WEST SUSSEX COUNTY COUNCIL CONSULTATION

TO:	Arun District Council FAO: Andrew Wood
FROM:	Highways, WSCC – Matthew Bartle
DATE:	8 May 2018
LOCATION:	Bradlaw House, 5 Sudley Road, Bognor Regis, PO21 1EJ
SUBJECT:	BR/52/18/PL Change of use from mixed use development consisting of Dental Surgery (D1 Non-Residential Institutions), night club (Sui Generis) & part residential (2 No. units existing) (C3 Dwellinghouse) to conversion to 8 No. flats with associated services (6 No. new units). This application may affect the setting of a listed building.
RECOMMENDATION:	☒ Advice ☐ Objection ☐ Modification ☐ No Objection ☐ More Information ☐ Refusal
\$106 CONTRIBUTION TOTAL:	£ to follow See below for breakdown.

Site Plan (Ground Floor, Proposed) 1:100

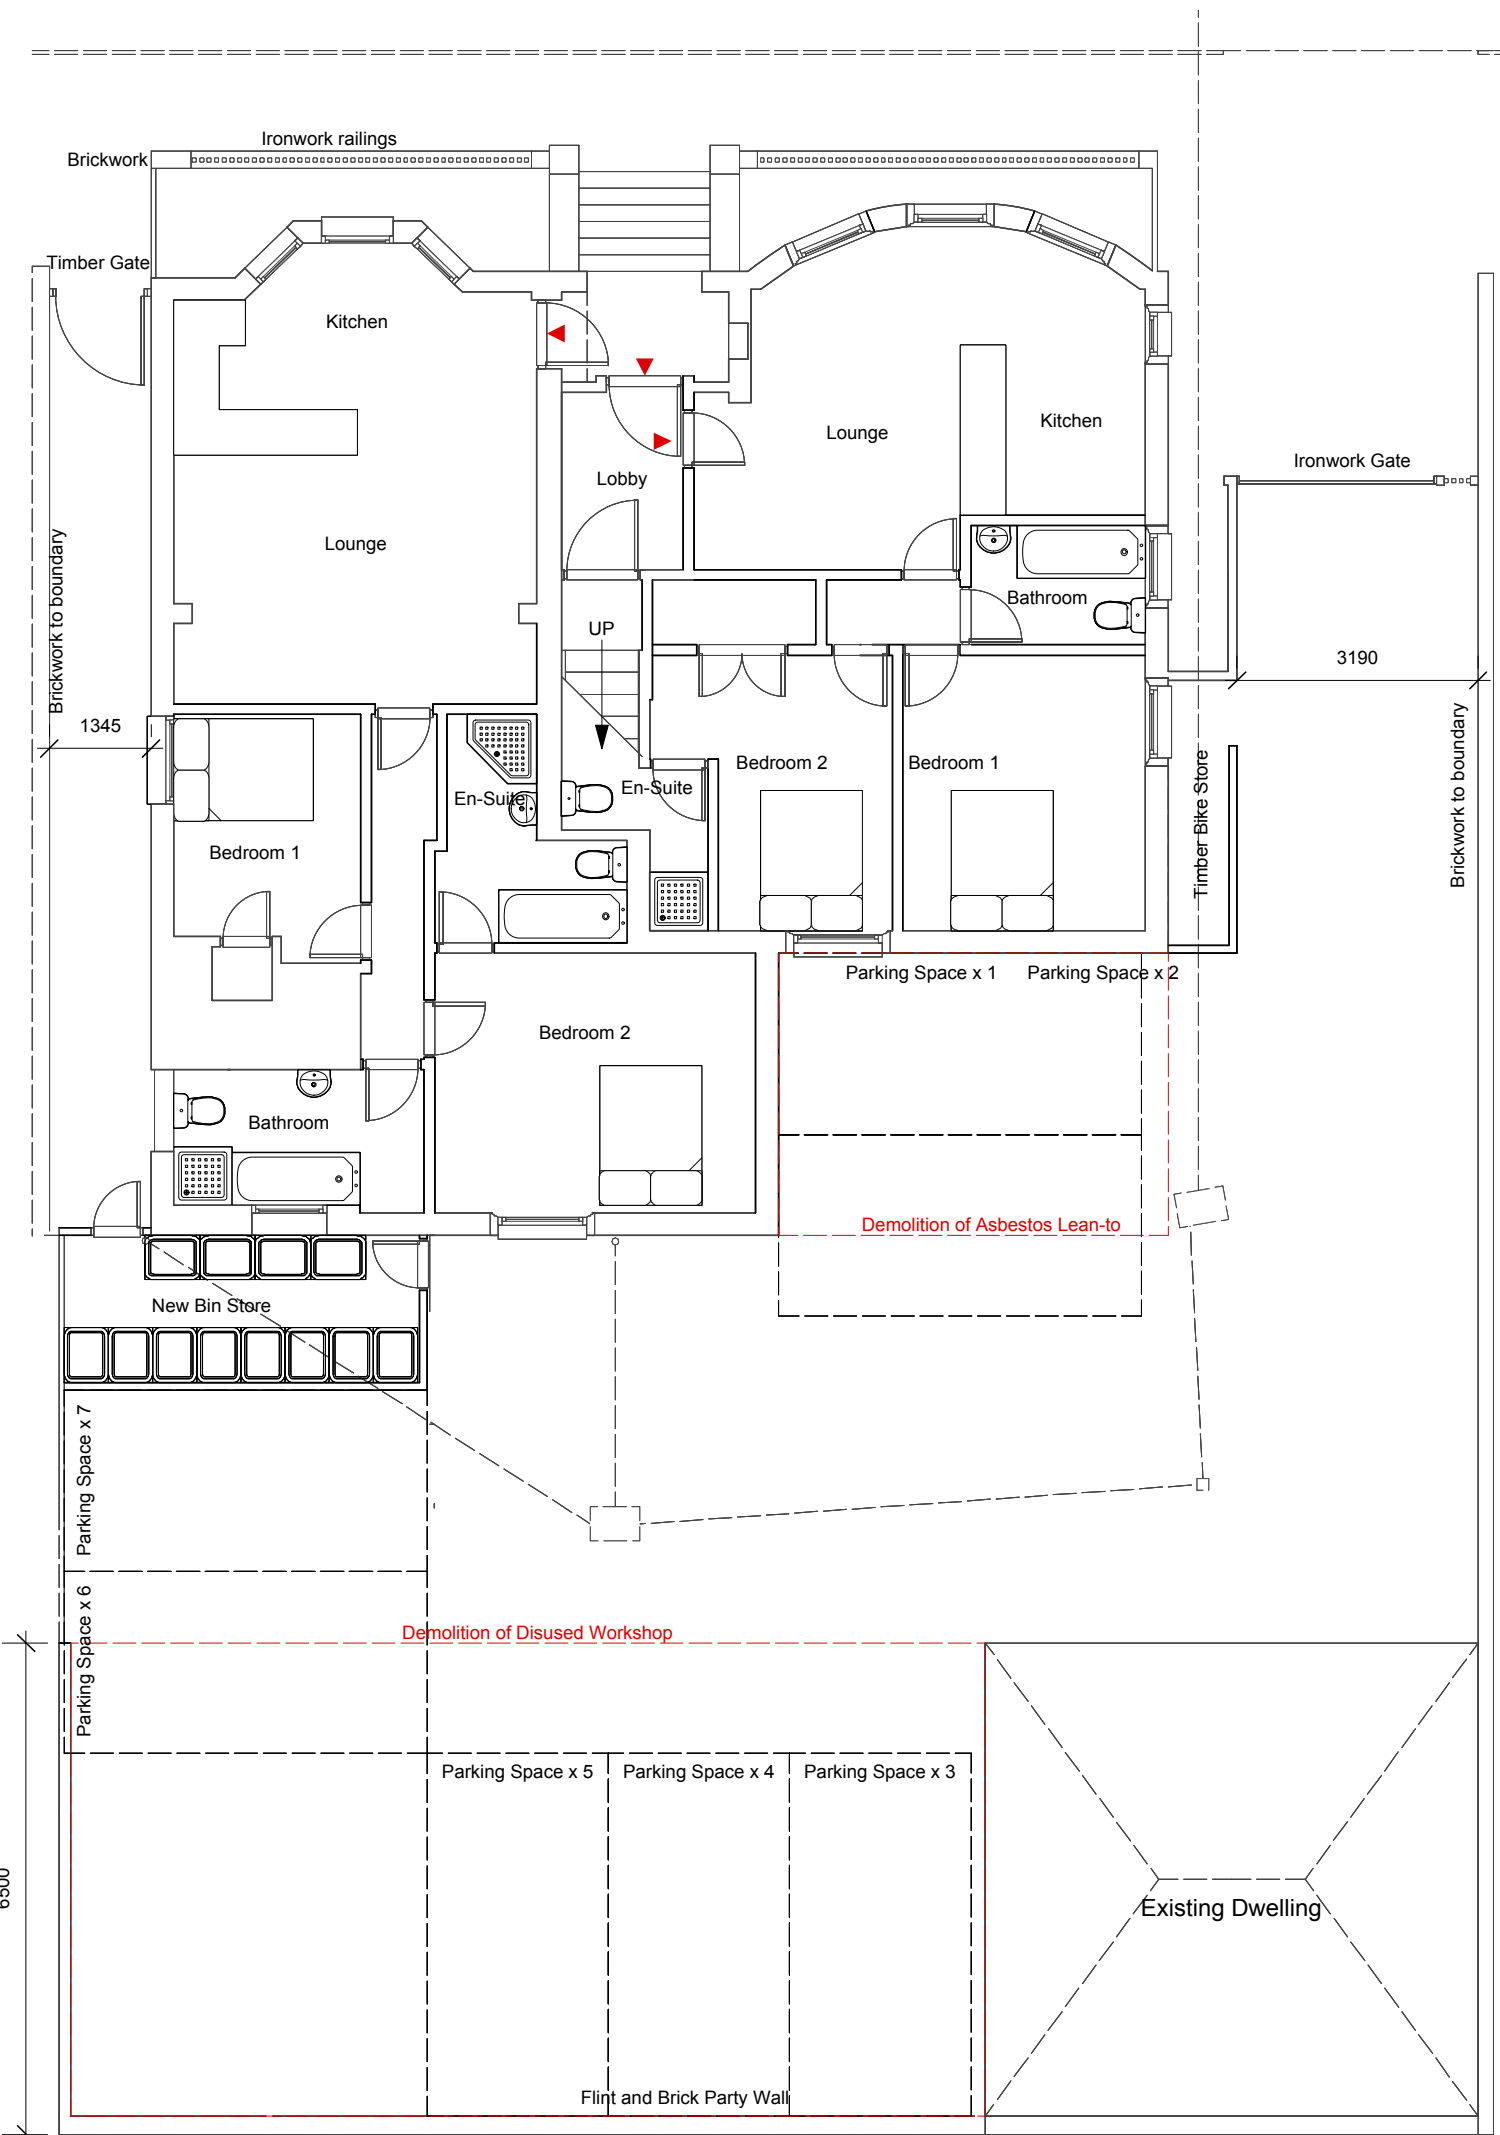
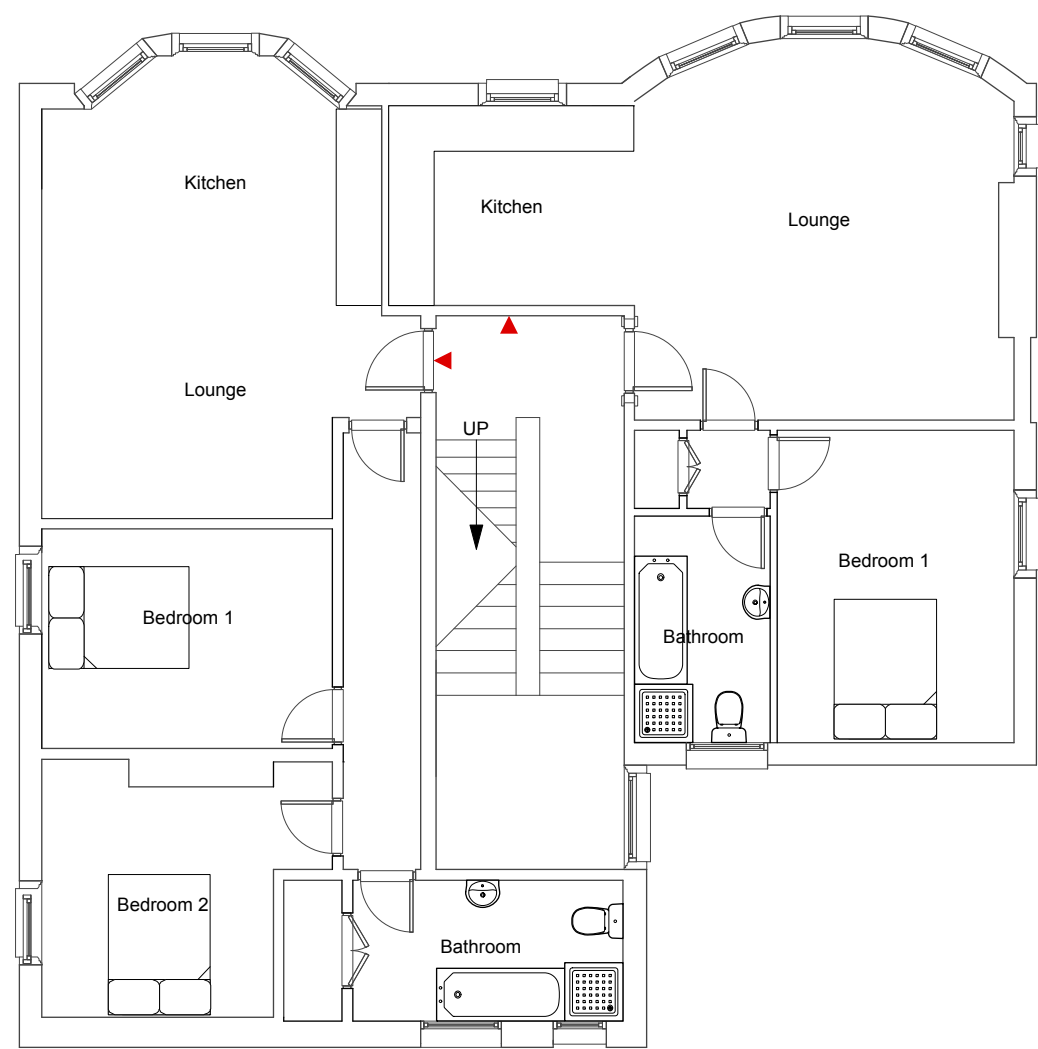
- the entrance through the gate from Sudley Road is 2.6m wide and the 3.2m width of the rest of the entrance-way does not give room for two vehicles to pass
- the room for manoeuvre round the car parking spaces is very restricted
- it is not clear how the occupier of the existing home at the rear of the site will get to their property
- the refuse bins are in a very restricted place behind the main building and there may be a tendency for residents not to want to cart them to the front
- there is no sign of a lift or shallow stairway between floors. How would residents get their furniture in and out and how would people in a wheelchair or with a baby buggy get from floor to floor?
